Date
28 September 2023

Immingham Eastern Ro-Ro Terminal (IERRT) – TR030007 Draft DCO: Requirement 18 – Impact protection measures

I write on behalf of my client Associated British Ports, the Applicant, in relation to the above proposed development.

Figure 1-1. Vessel Impact Protection Structures

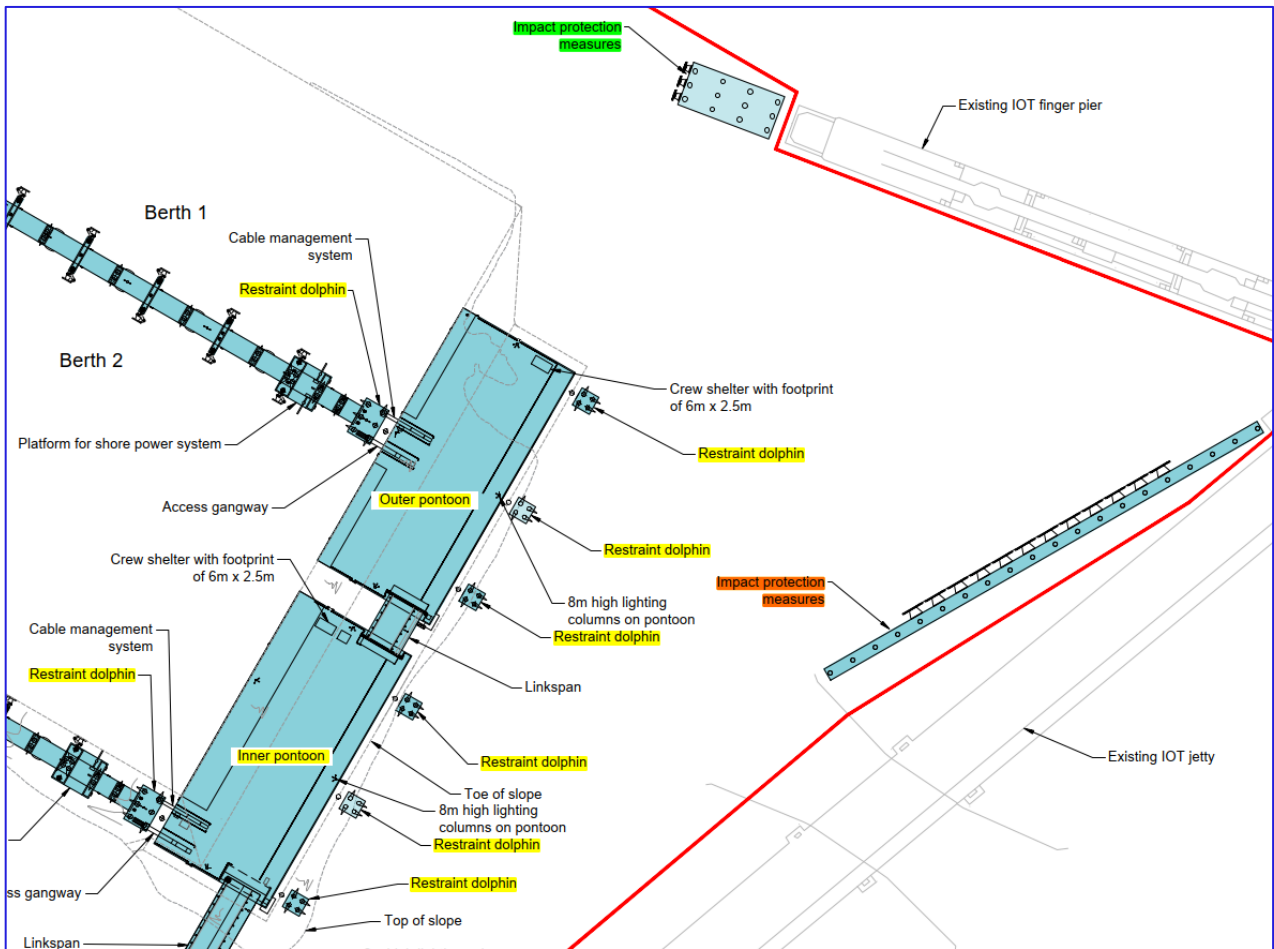
- 1 The revised layout for the IOT finger pier will enable a second Coastal tanker to berth on the northern side of the finger pier whilst retaining two barge berths on the finger pier;

- 2 The relocated impact protection measures, whilst being constructed to a standard that will retain a vessel drifting towards the IOT trunkway or the IOT finger pier, will be so located as to enable APT's barges still to berth on the southern side of the IOT finger pier; and

- 3 The IERRT infrastructure will be sufficiently resilient to arrest a vessel drifting in a southerly direction towards the IOT trunkway.
- 4 The engineering design of those measures will be subject to approval by the IOT (with provision for arbitration in the event of dispute)

- 5 The measures will be implemented prior to the commissioning of any berth in the IERRT facility unless otherwise agreed in writing.
- 6 ABP will indemnify the IOT Operators for the IOT Operators' costs relating to the revised protection measures and for any business losses occurring as a result of the installation of those measures substantially in accordance with the protective provisions in REP1-039.
